**Subject:** DOCO comments for application 2026/90018 at 26 Hillcrest View, Golcar, Huddersfield, HD7 4FD

Re: 2026/90018- Discharge of details reserved by conditions 7 (boundary treatments), 8 (external lighting), 9 (pedestrian link), 10 (landscaping), 11 (biodiversity enhancement and management plan) on previous permission 2024/91162 for deemed application via enforcement appeal (APP/Z4718/C/24/33427870 for erection of one dwelling (within a Conservation Area)

SCALE	DATE	DRAWN	CHECKED
1:200@A1	July 2024	PM	
DRAWING NO.	CAD REFERENCE NO.	REVISION	
R-0873-60		E

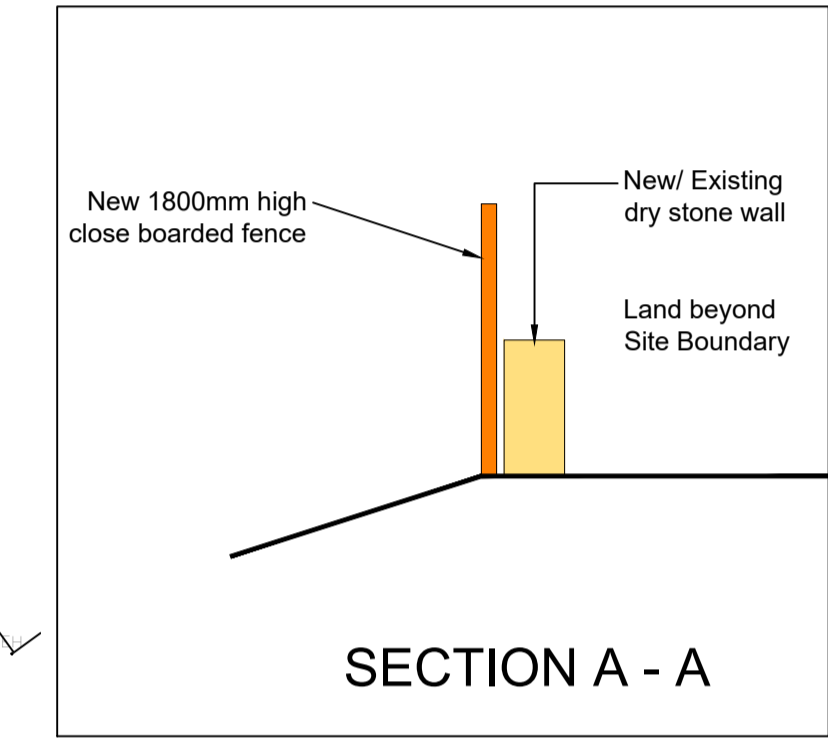
A part of the rear boundary of plot 12 will be scalable as the dry stone wall is located immediately behind the 1800mm close boarded fence (as illustrated on the site plan) and can be used as a climbing aid:

Additional trellis topping would be beneficial for this particular location.

However, in light of this boundary abutting private rear gardens of other residential properties located on Carr Top Lane rather than public/ open spaces, the condition can be discharged. Plot owners should be advised to place some defensive planting (e.g. thorny hedgerows) where dry stone walling is immediately adjacent to their boundary (see below, marked with a blue line) to mitigate this risk:

I note my predecessor's feedback with regard to street lighting dated December 2022 (document id 1120053). I note that 2 dusk till dawn luminaires have been added in line with his recommendation, to provide additional illuminance between plots 12 and 13.

With regard to external lighting for each dwelling- all entry/ exit points (i.e. external doorsets, including patio and garage doorsets) should be illuminated with dusk till dawn lighting.

This was included in both my colleagues' recommendations under applications 2021/91384 and 2024/92153. I cannot locate any information to this effect amongst the submitted documents.
